**42 Honeysuckle Drive, Newcastle – Amending SSD (SSD-10251)
Response to Submissions**

Having reviewed the submissions and considered the proposal, the Department requests additional information (as set out in **Attachment A**) to progress your application.

Attachment A

General Arrangement Plan
Level 09 Roof

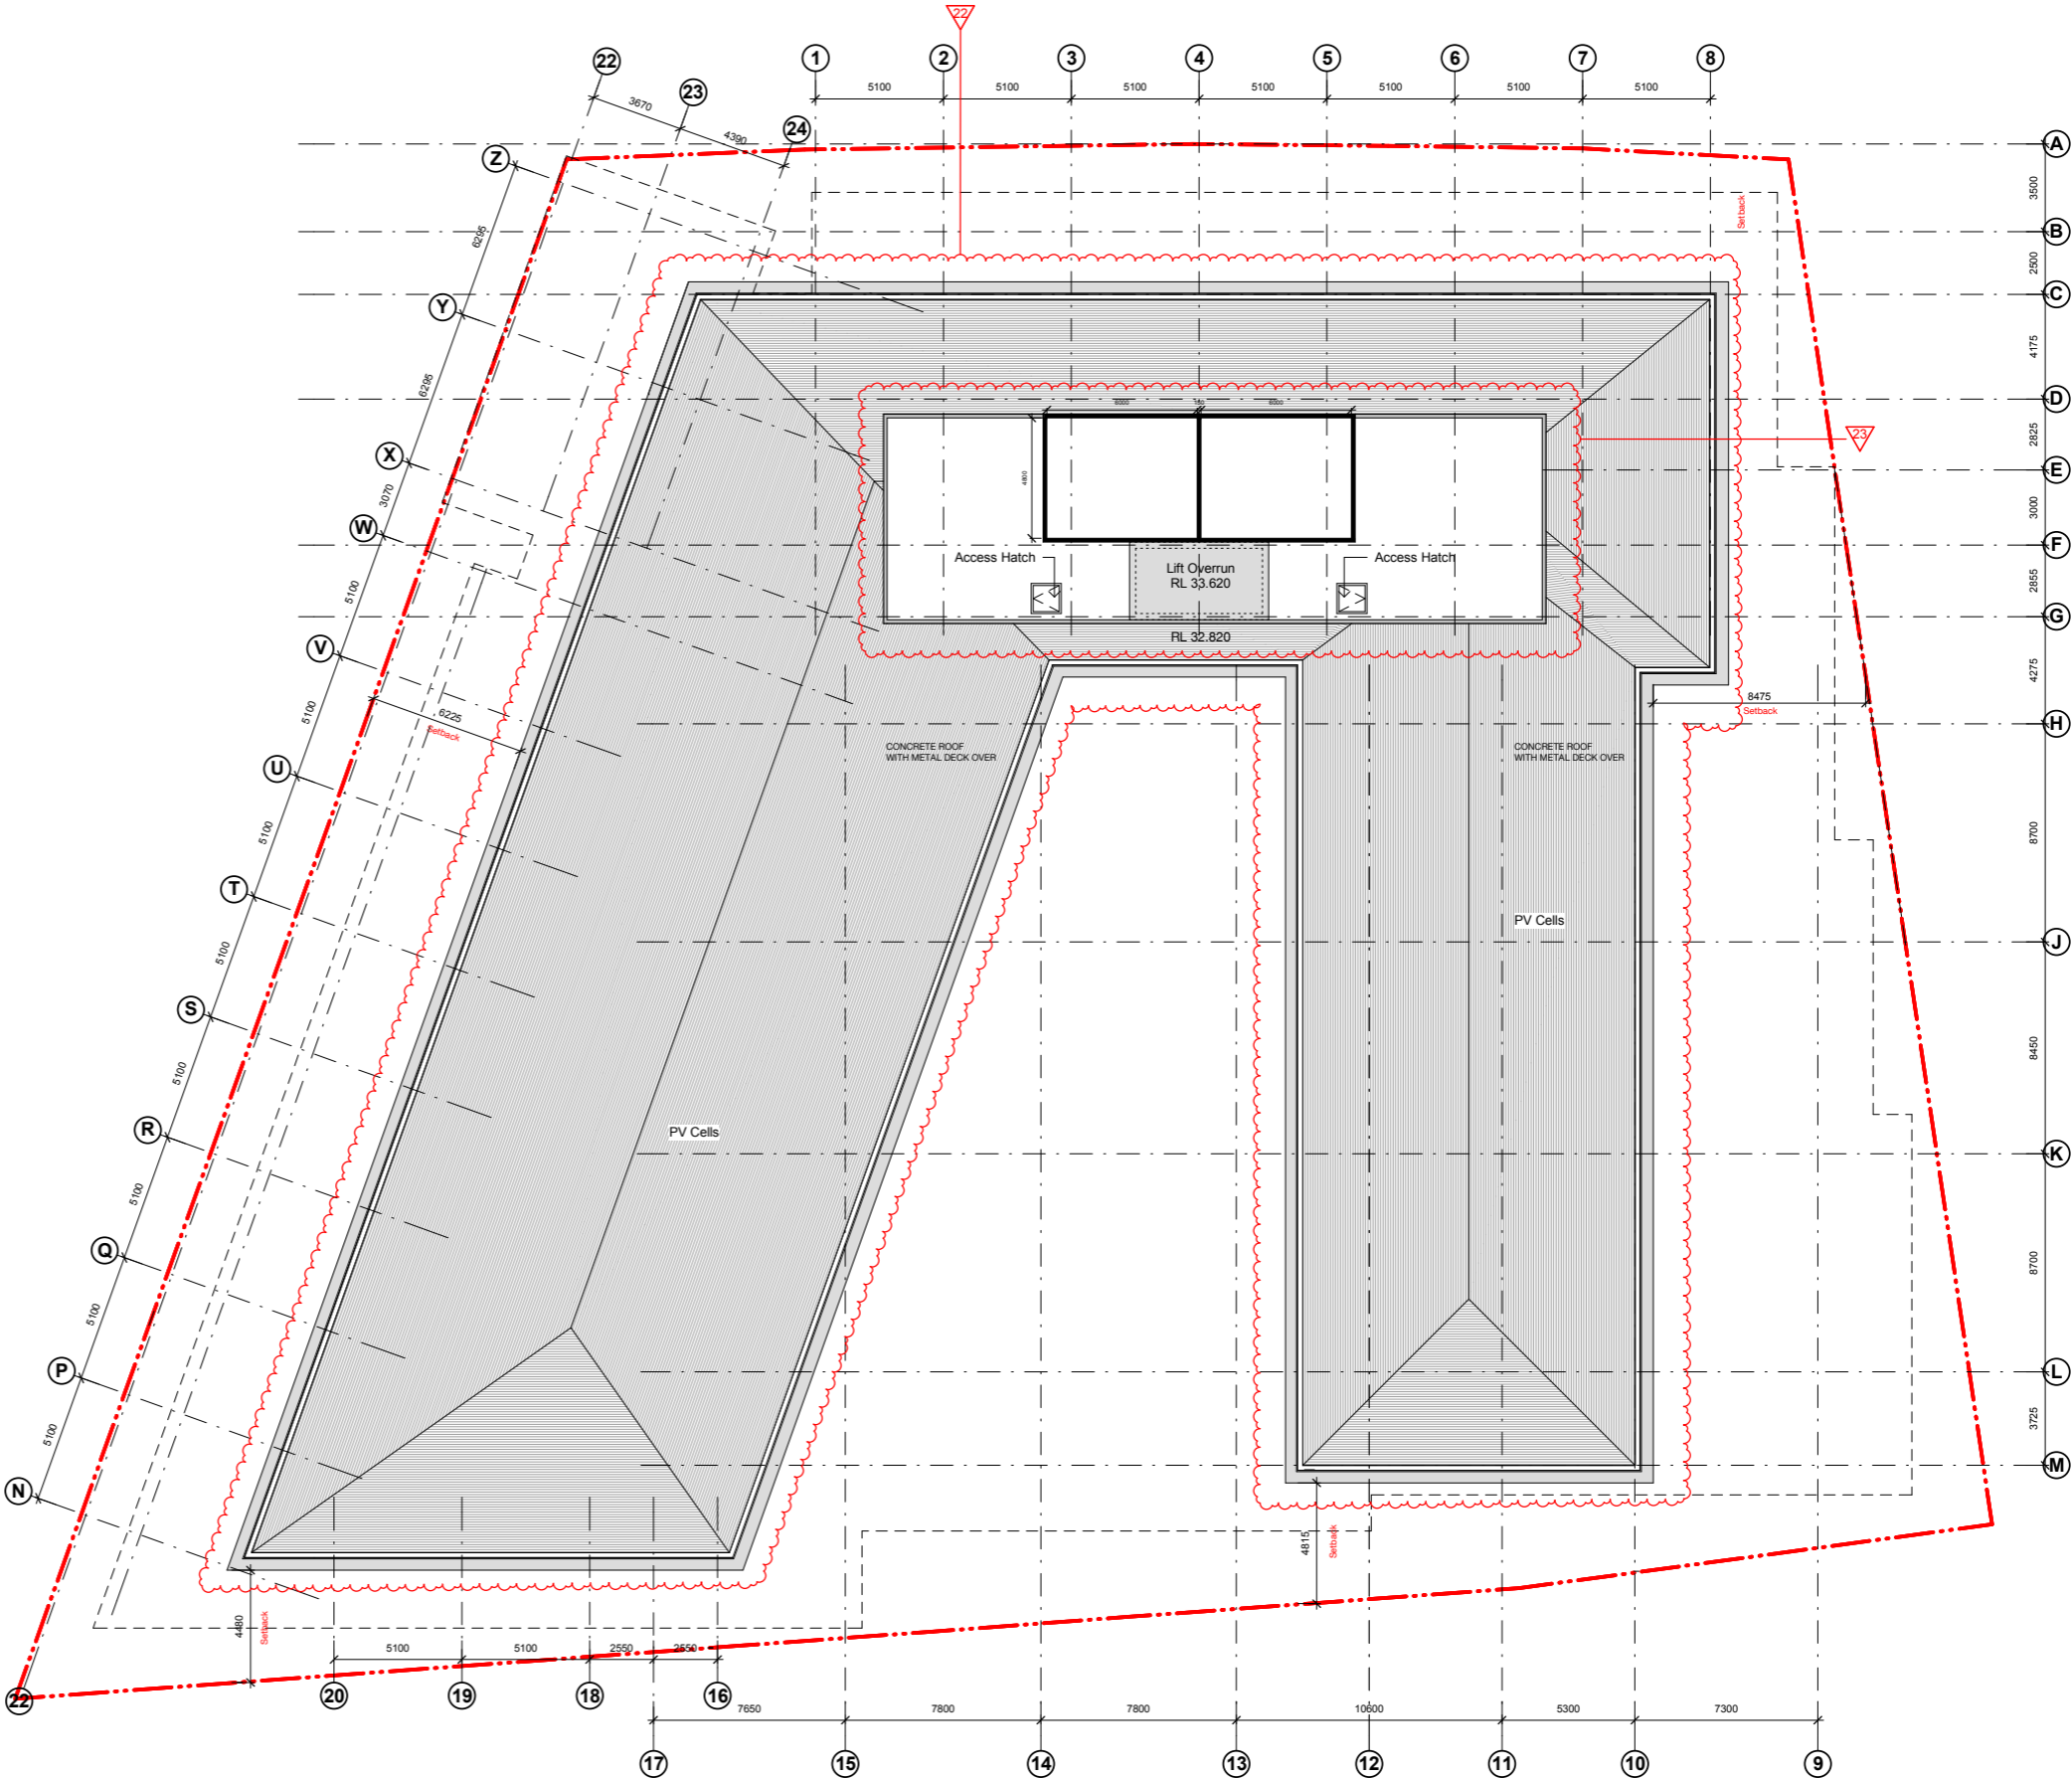
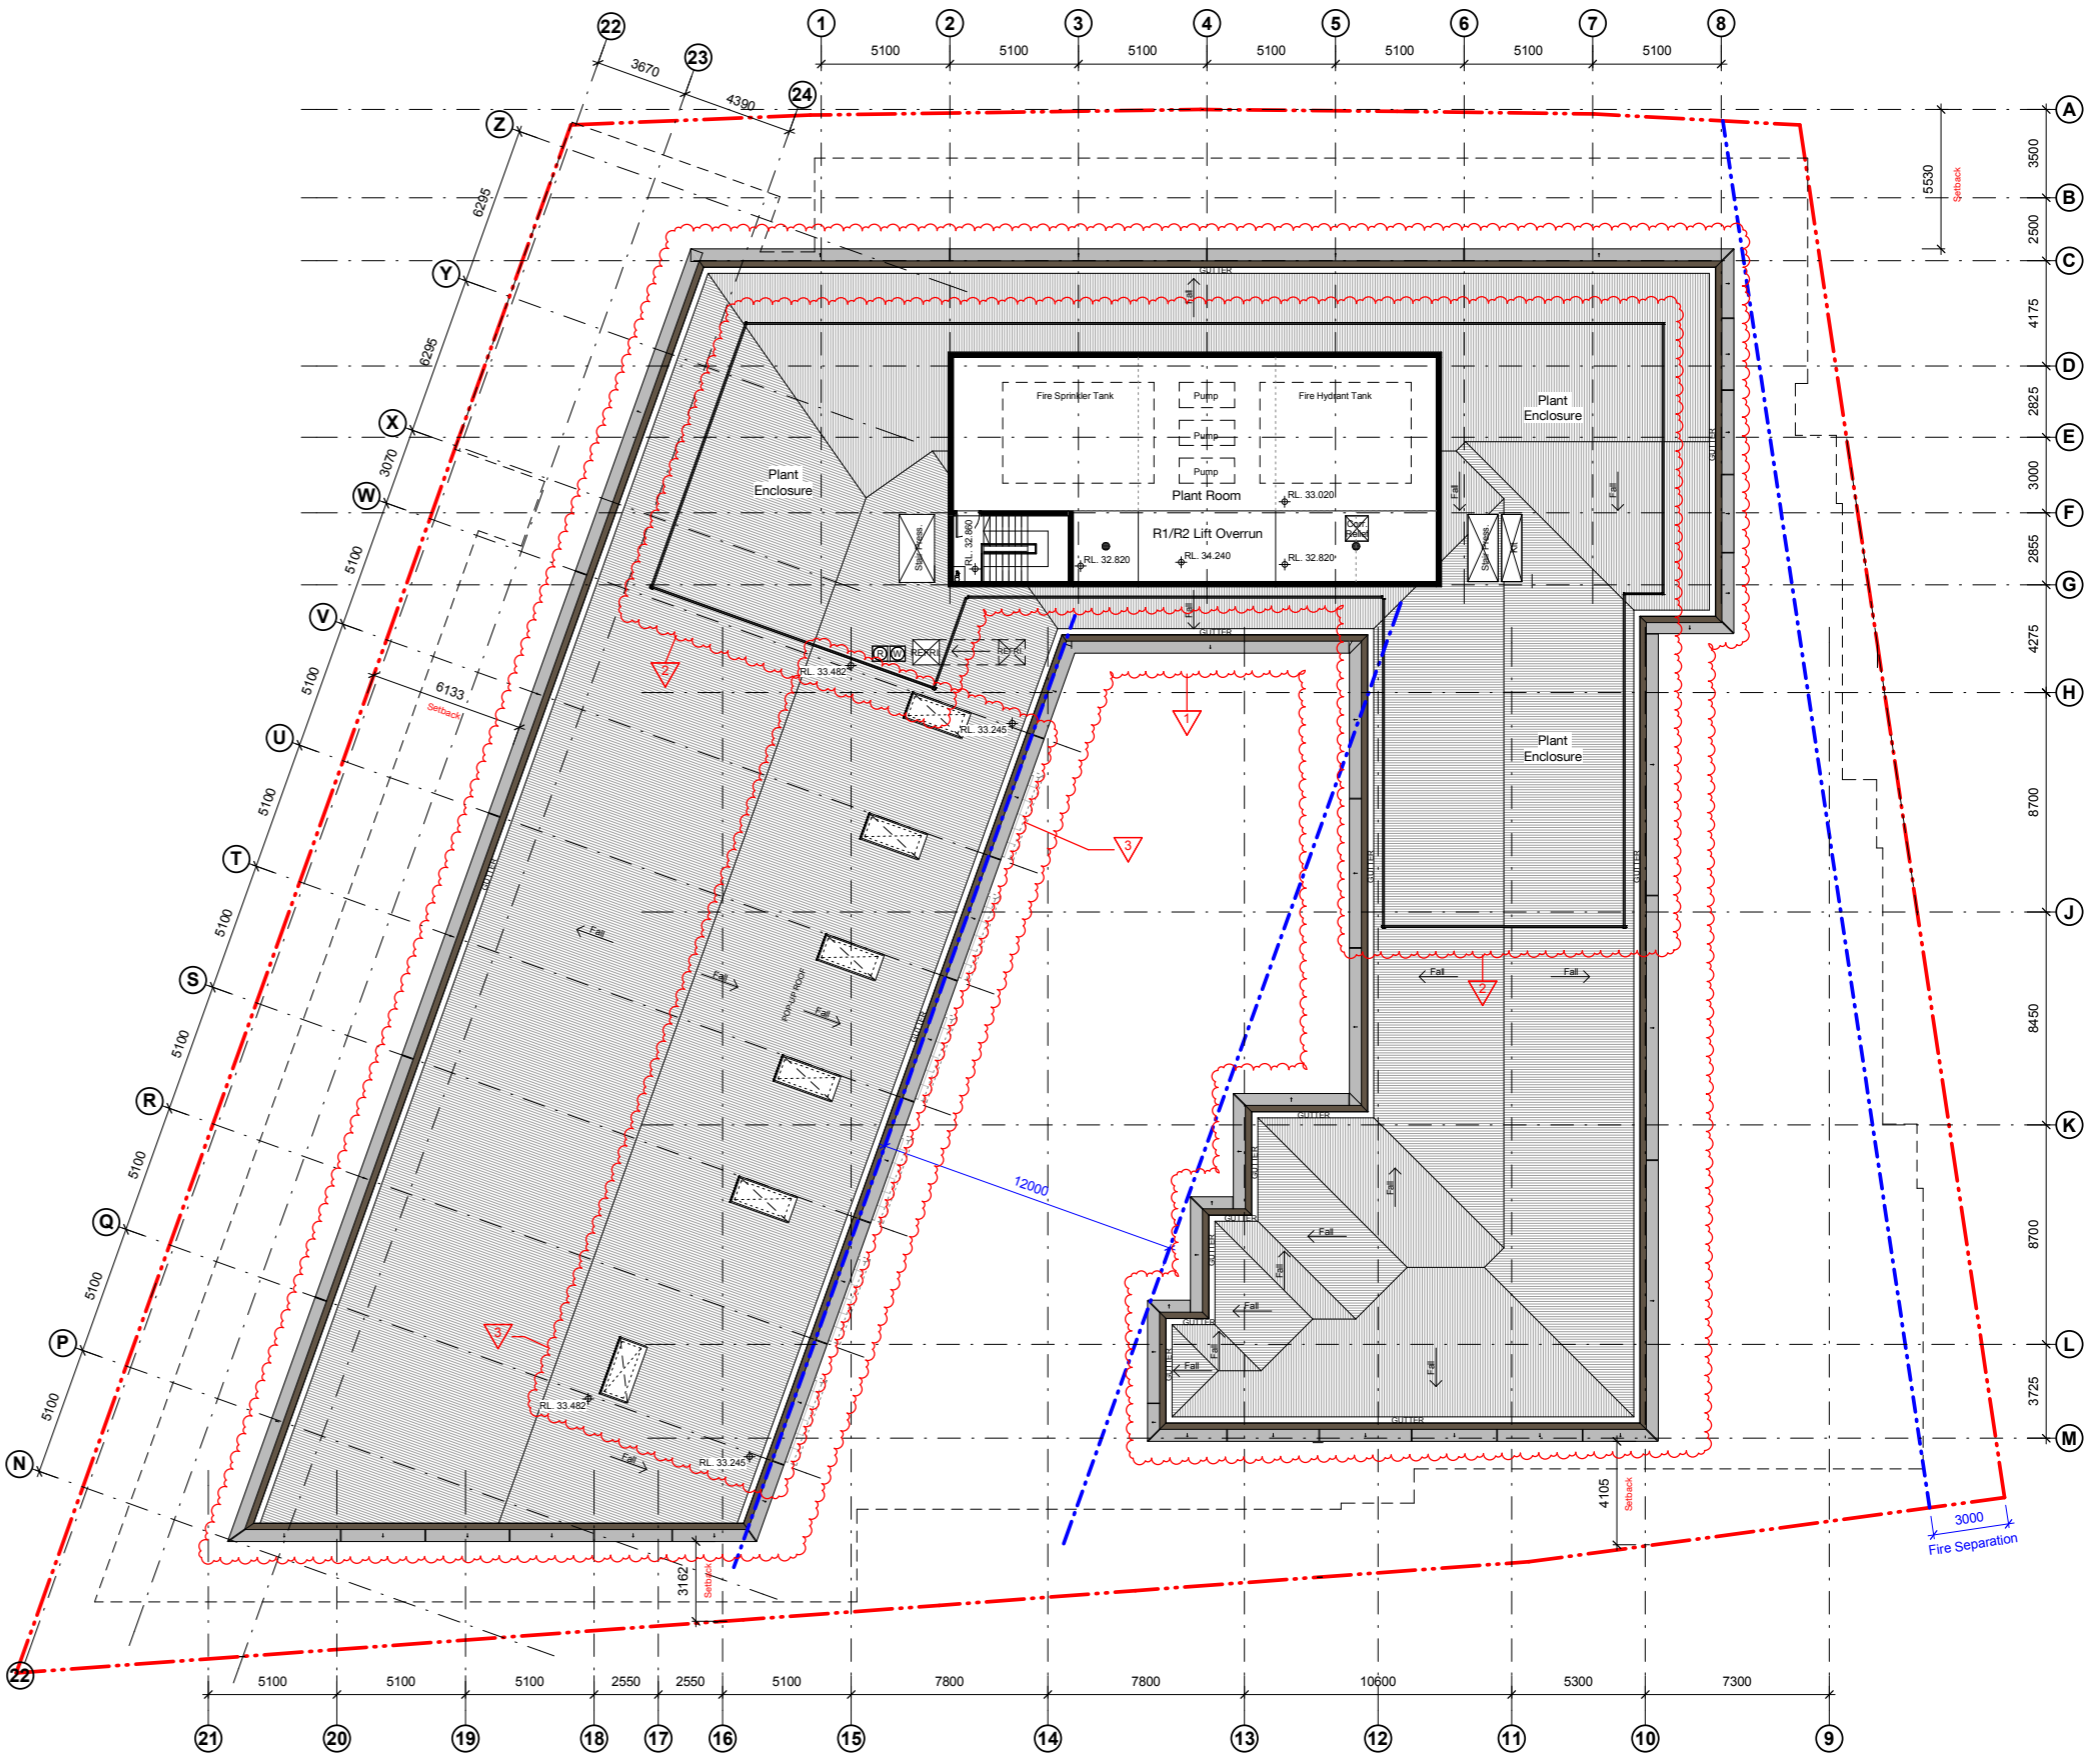
- Please review the architectural plans for accuracy and completeness to ensure they fully reflect the amendments sought as part of the proposal. All changes should be shown clouded on the proposed plans.
- The Department has identified several changes on the submitted plans which have either not been described or inconsistent with the EIS:
 - the access to the waste storage area and bicycle parking arrangements on the ground floor
 - the addition of three car parking spaces and inconsistent allocation of car parking spaces
 - removal of the photovoltaic cells on the roof despite referencing them in the design report.

All amendments should be clearly highlighted and described/justified as appropriate in the Response to Submissions.
